Directorate for Economic Growth and
Regeneration
PO Box 4
Town Hall
Lancaster
LA1 1QR

Your ref: 3/2025/0318
Our ref: 3/2025/0318/HDC/KW
Date: 27 May 2025

Location: The Old Garage Site Newton Road Dunsop Bridge BB7 3BB
Proposal: Approval of details reserved by conditions 3 (materials), 4 (location of existing water mains and sewers), 5 (drainage scheme), 6 (construction traffic management plan), 9 (cycle storage), 10 (surface water drainage car park), 11 (delivery and servicing plan), 13 (bird and bat boxes) and 14 (electric vehicle charging points) on planning permission 3/2023/0816.
Grid Ref: 366038 450100

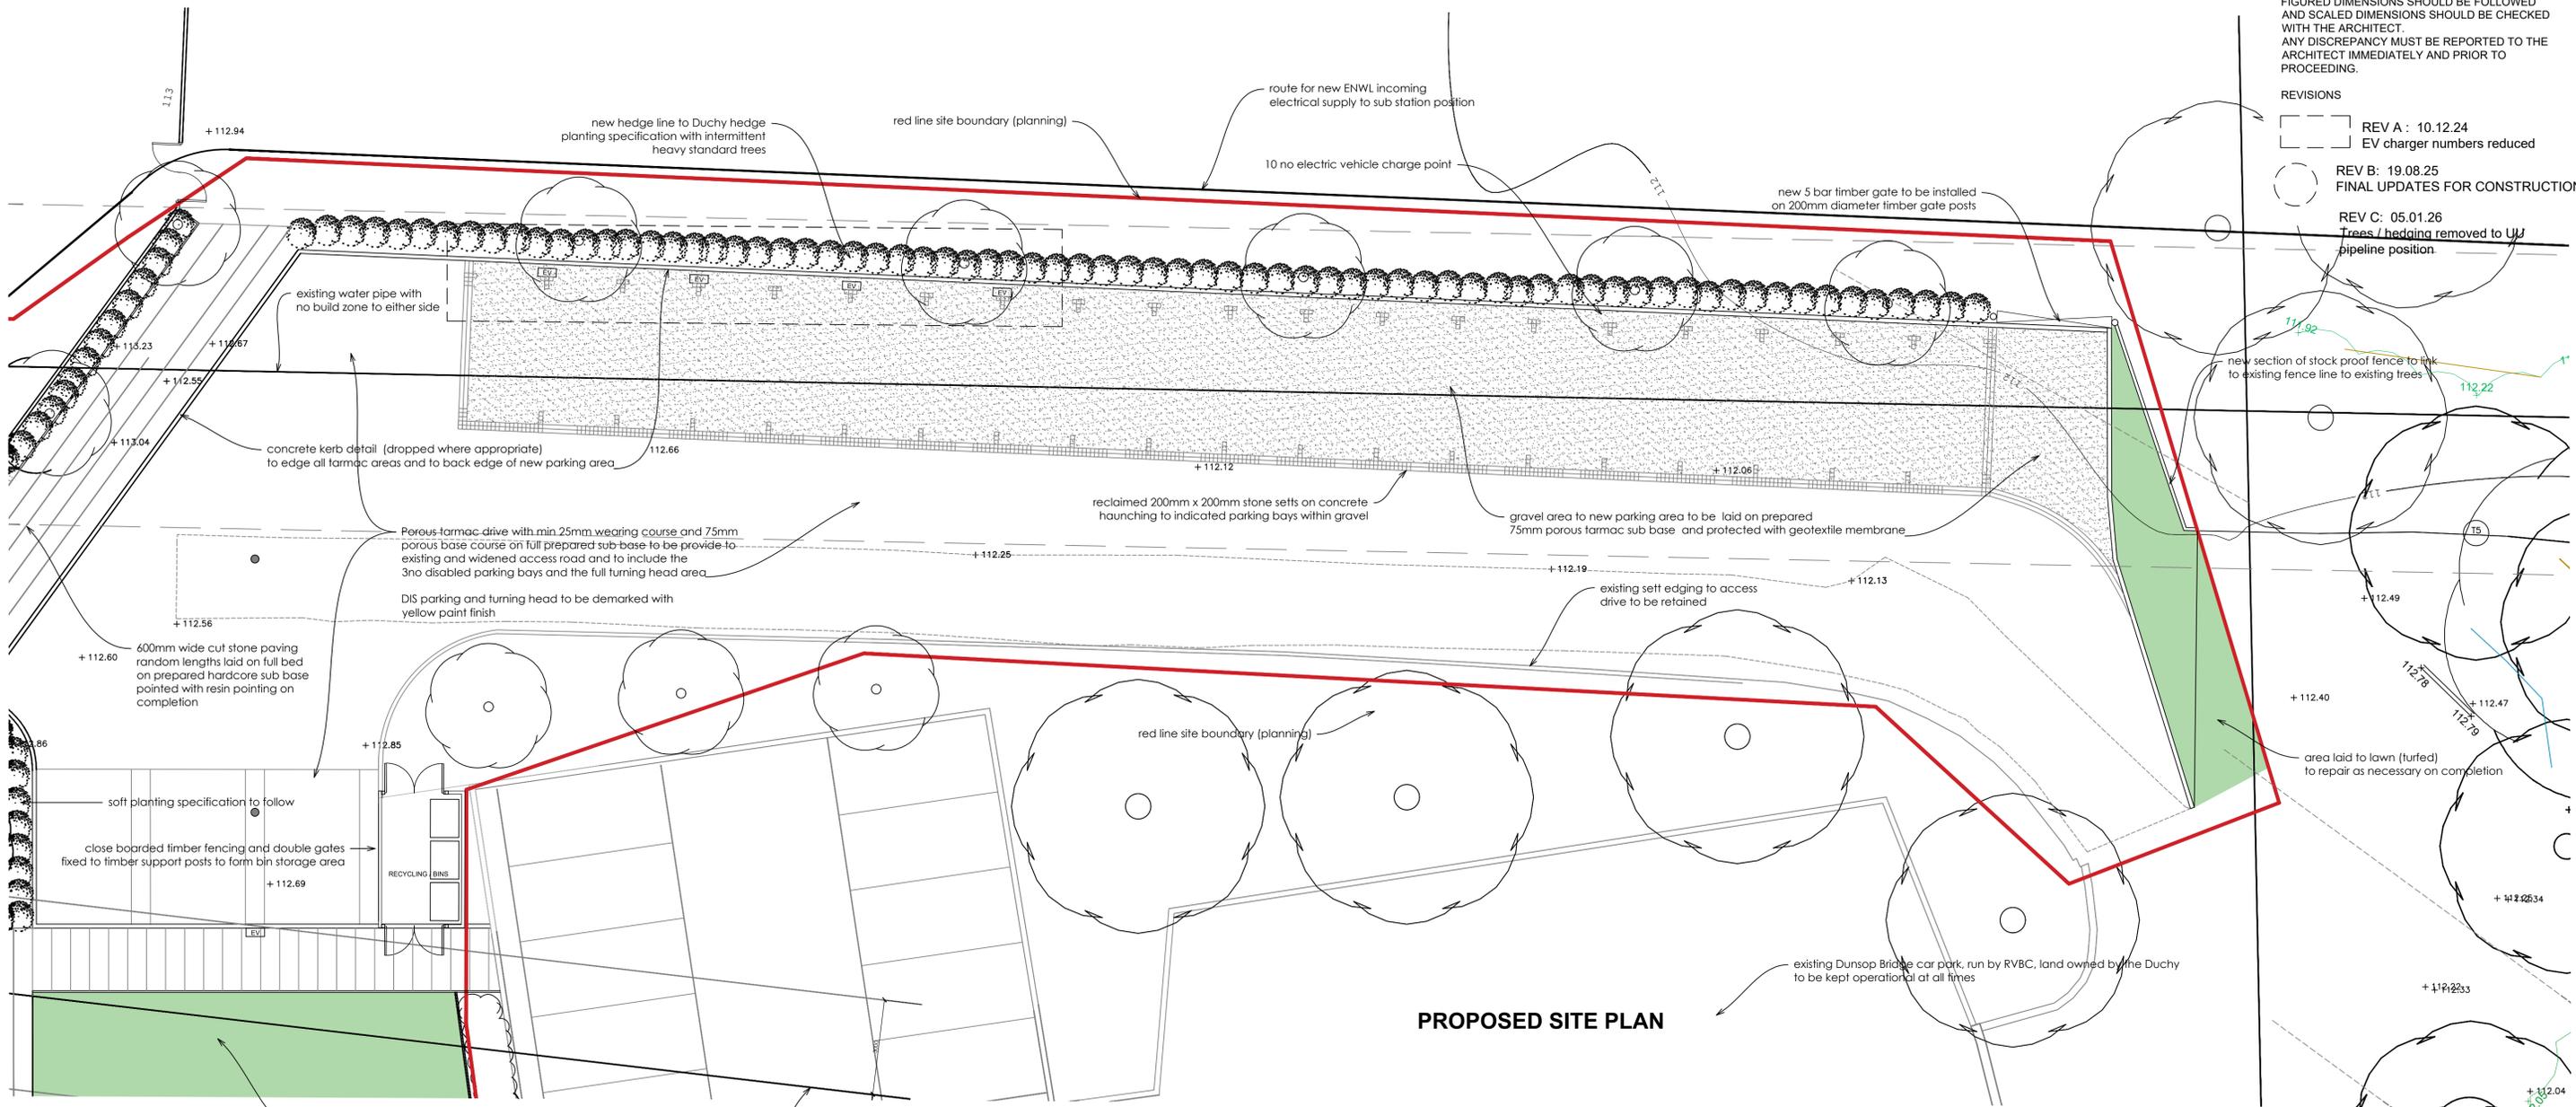
The LHA have reviewed the details provided regarding the cycle storage facilities and note an 8 space Amazon Eco Cycle Shelter will provide covered secure cycle storage along with cycle hoops adjacent for short term storage options as noted within the proposed landscape, drawing HB106, WD23, A.

However, the applicant has not provided evidence of the cycle storage in place on site as such this condition can only be partly discharged due to the condition stating that cycle stores shall be provided and available for use prior to the occupation of the associated plot or in the case of the flats prior to occupation of the first flat.
